RE: Review Comments for Single Family Site Plan

Project Name: McDonald Two Family
Project ID: 2016-02072
Project Address: 84 Irving Street **CBL:** 137-A-001001

NORTH FACE ELEVATION  
84 IRVING ST. PORTLAND ME  
1/4 SCALE

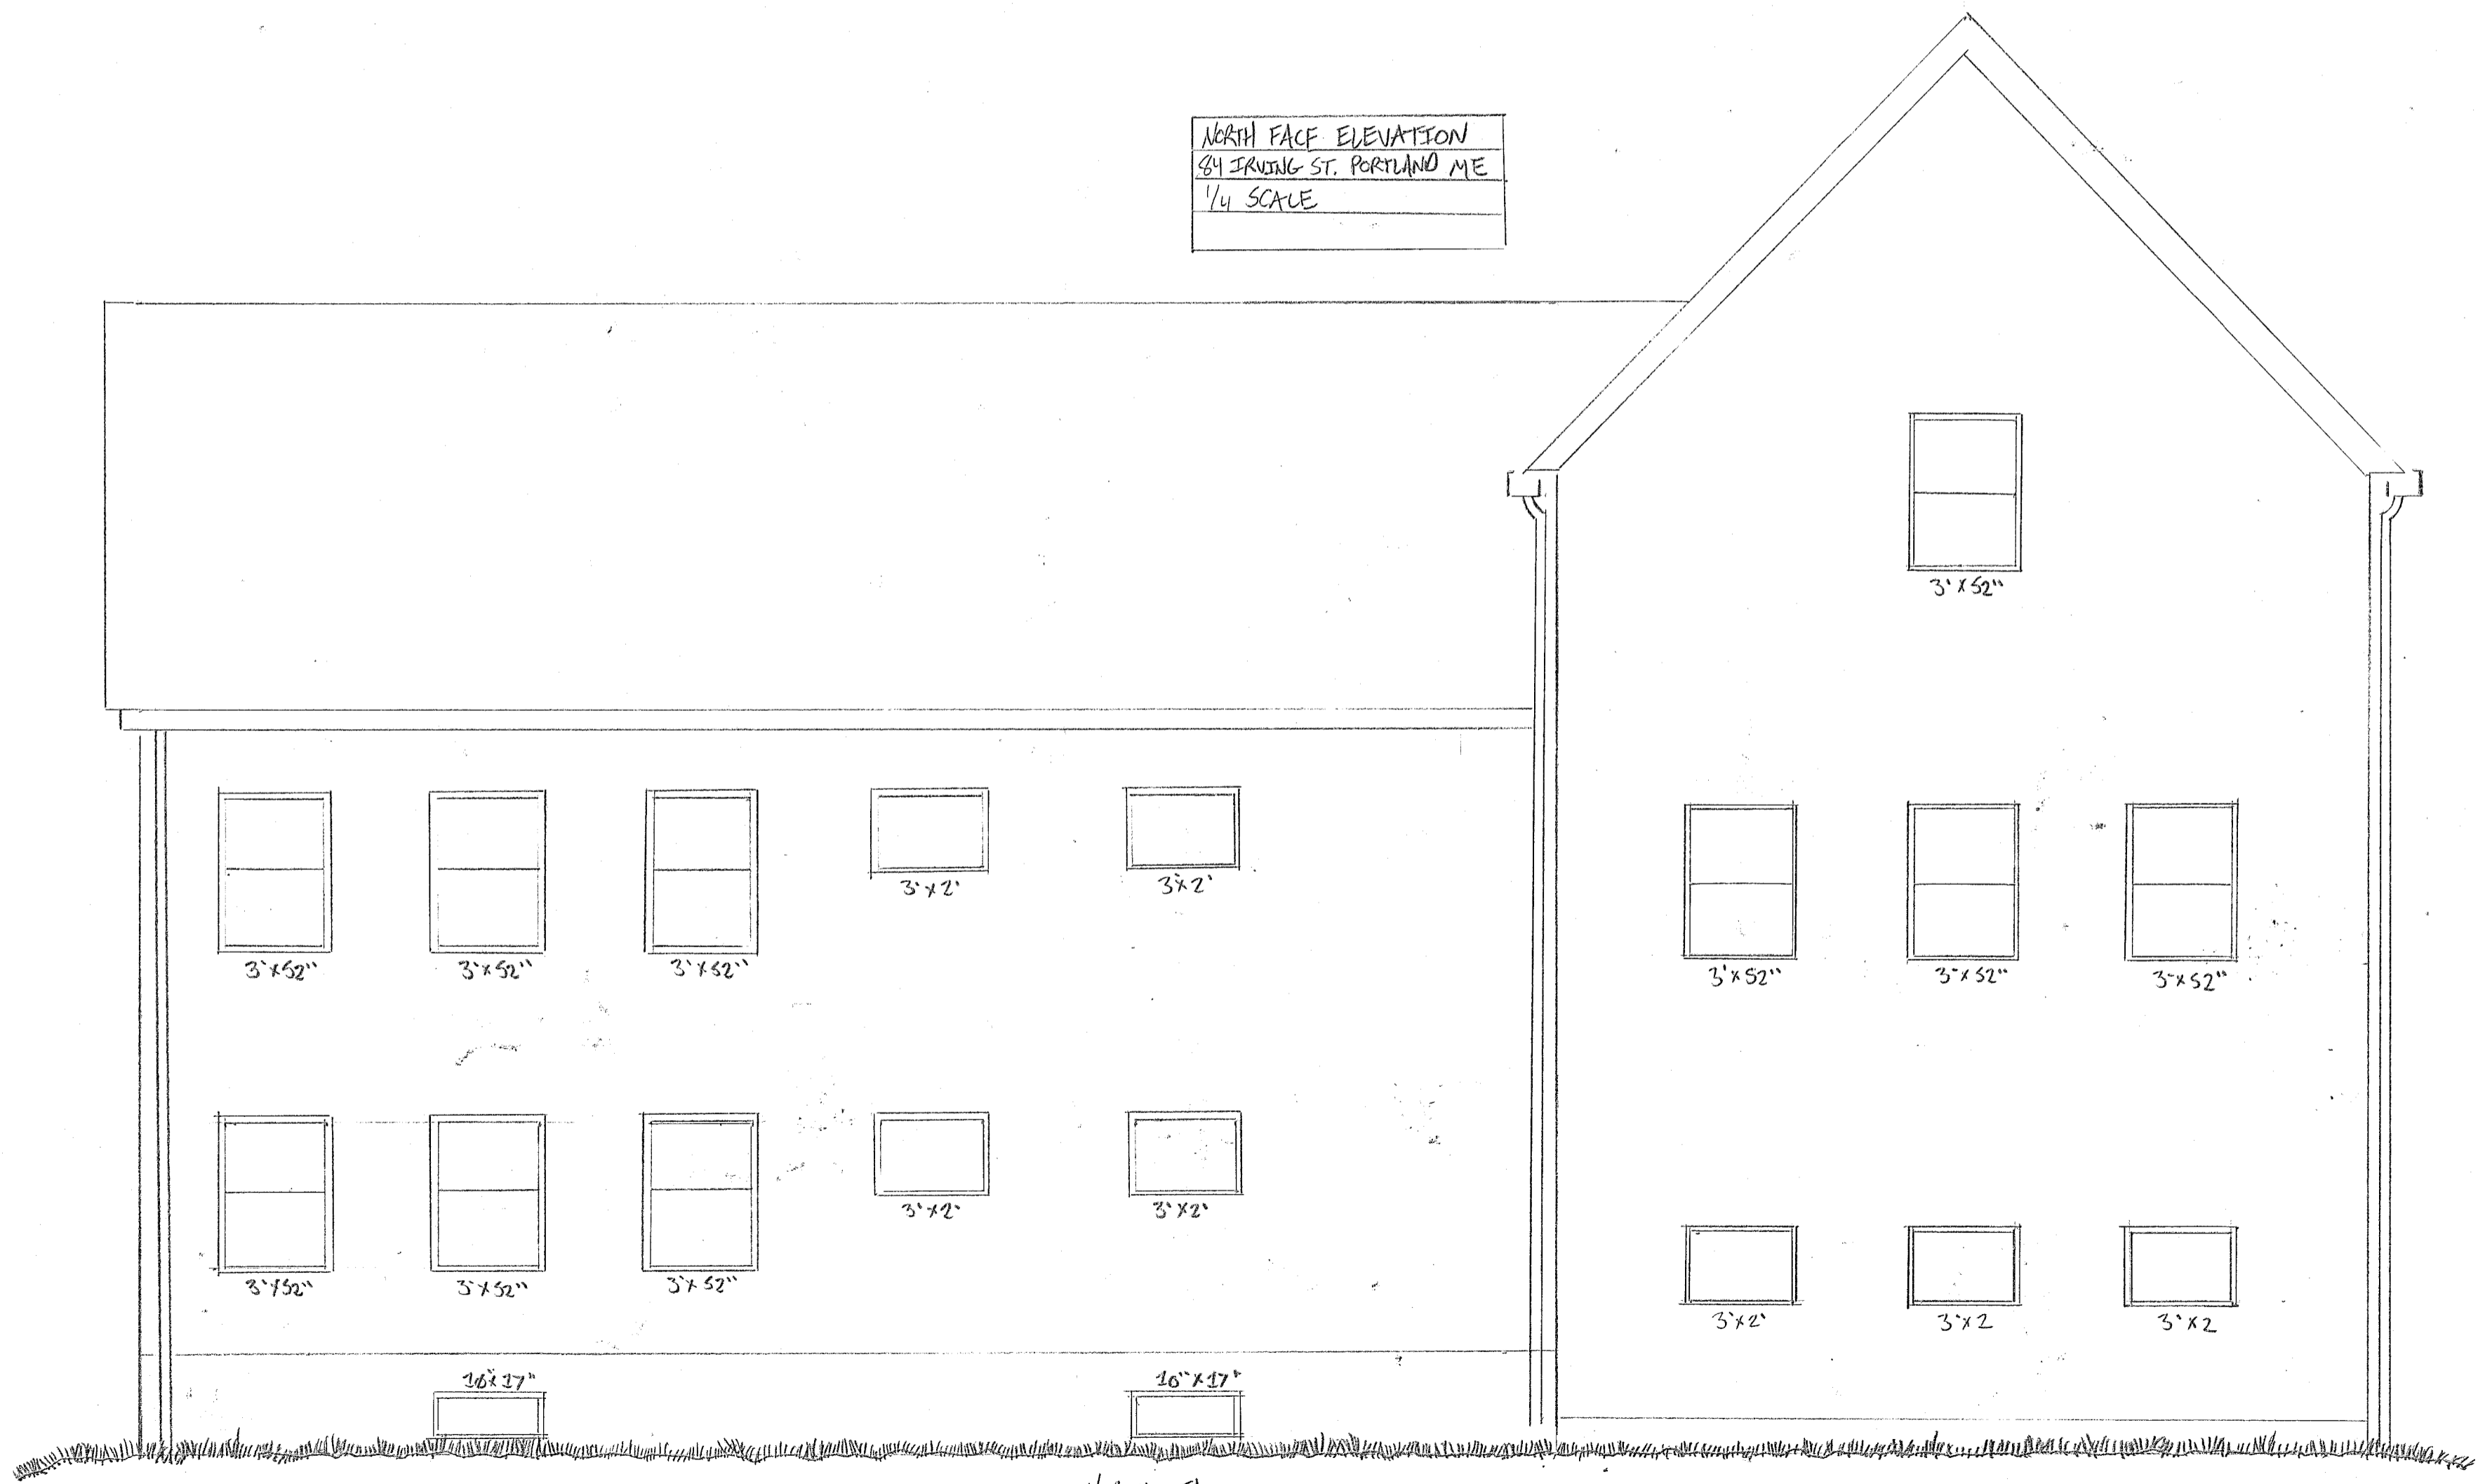
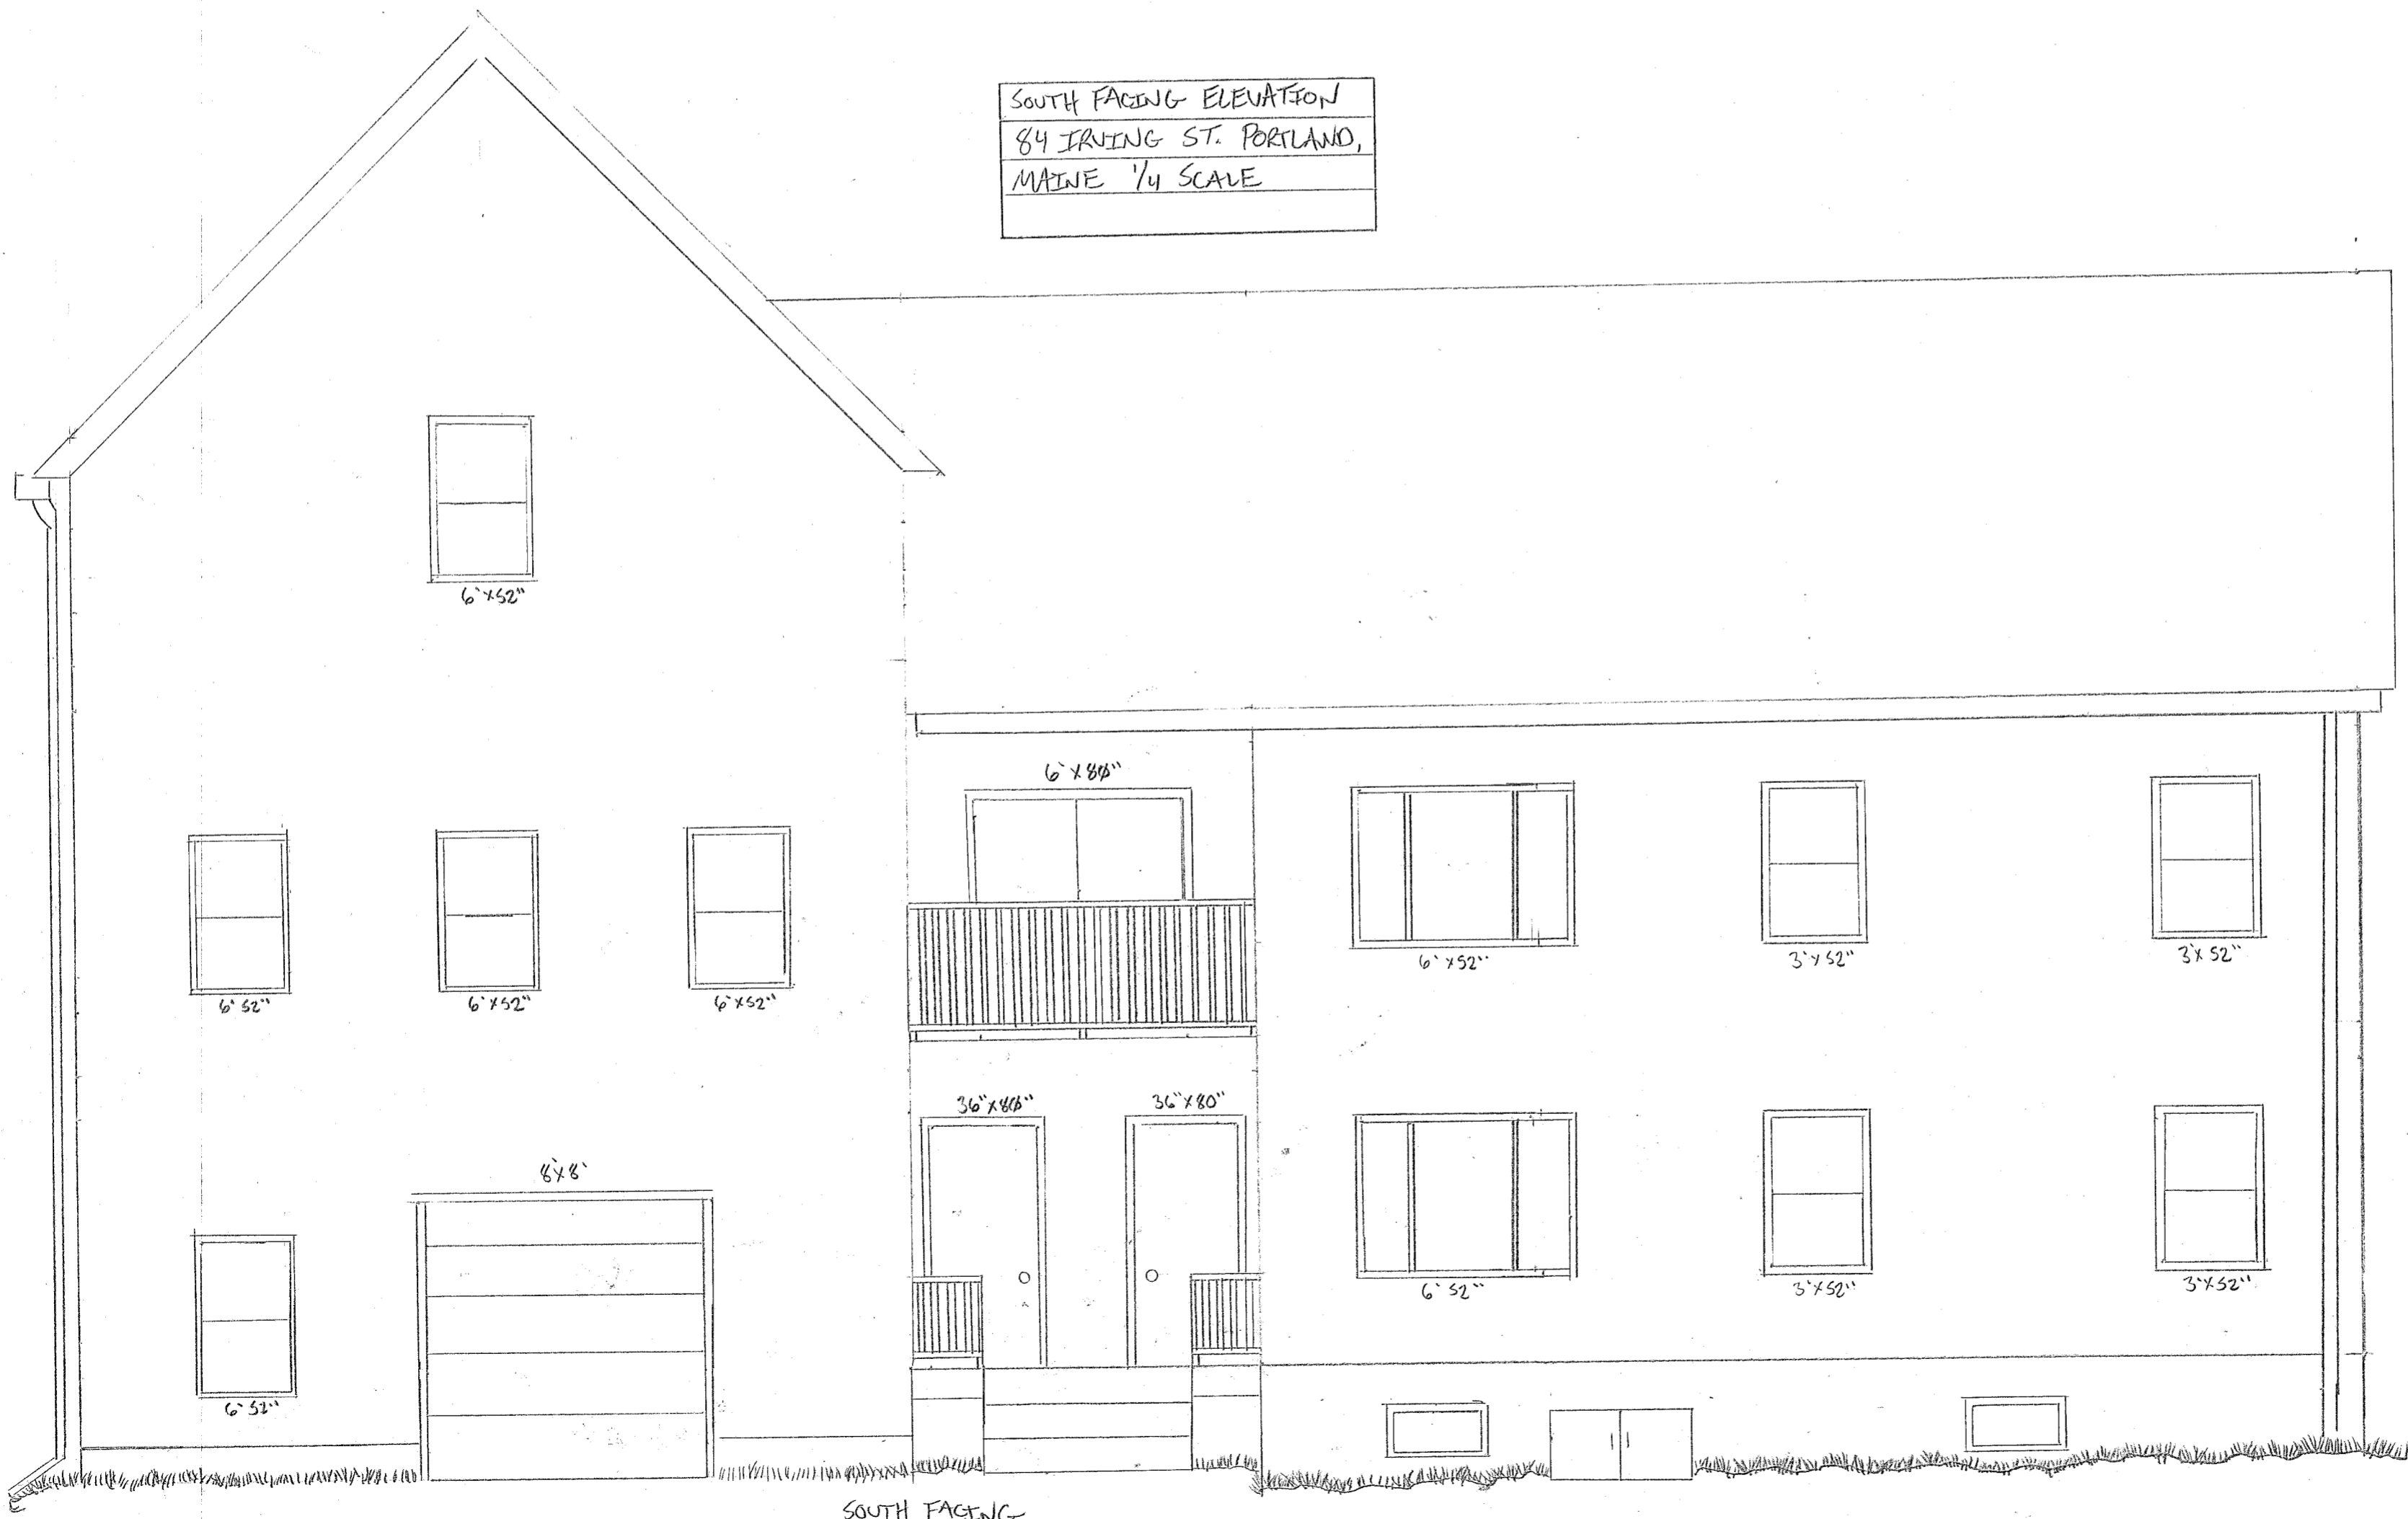
- PLEASE SEE THE PAGE OF 3 SKETCH DRAWINGS AS PROPOSED BY CHRIS STACEY ↗ • I have spoken with Zoning Specialist Chris Stacey regarding her review for compliance with the city's zoning ordinance. She identified a concern with the design of the new building. Based on photos of the now-demolished building, it appears that the previous attached rear barn/garage was a 1.5-story structure. The plans for new building show this portion will be reconstructed as a 2.5-story structure. When rebuilding a non-conforming structure in the same location, expansions like this are not allowed. The plans must be revised to

show that the rear garage will be rebuilt to the same dimensions, including height, as the old garage. If you have questions about this, please contact Chris directly at 207-874-8695 or orcstacey@portlandmaine.gov
